From: Andrew Hinton <[REDACTED]>
Sent: 14 June 2013 08:08
To: Charlotte Burrows
Cc: Planning
Subject: FAO Charlotte Burrows - 9 Shirley Close, Pagham, West Sussex. PO21 4QU - P/51/13

Re - 9 Shirley Close, Pagham, West Sussex. PO21 4QU - P/51/13

Proposed **Ground Floor Plan** at 1:100 scale

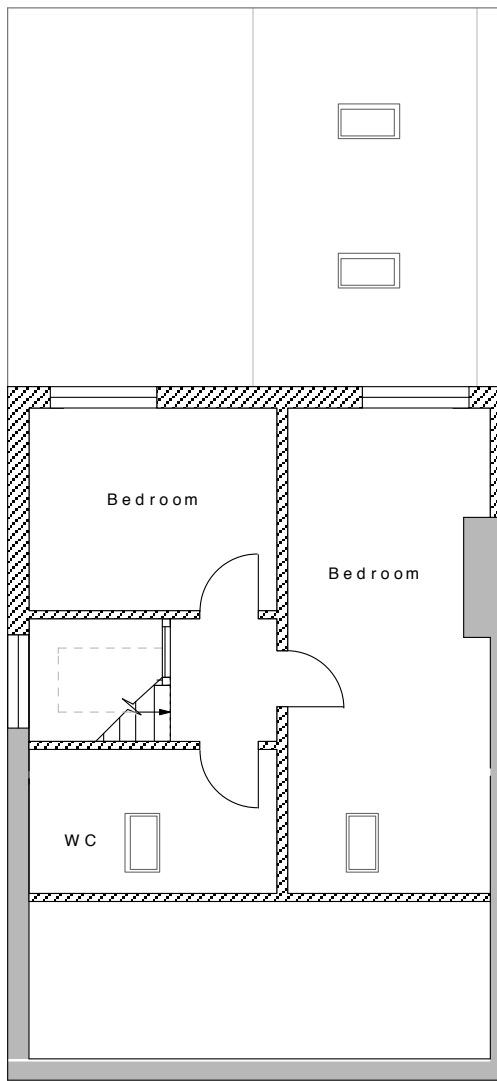
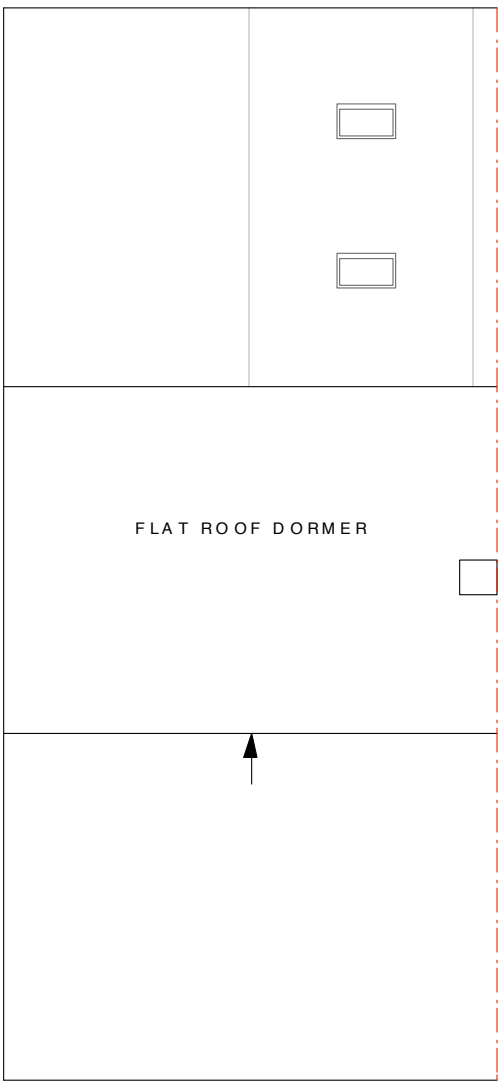
Thank you for your letter dated yesterday. Just to confirm the proposed window on North elevation is half way up the staircase and so halfway between GF & FF. This is why it is shown as one window on the elevation but appears on both GF & FF plans. From our point of view this is correct and hope you will concur.
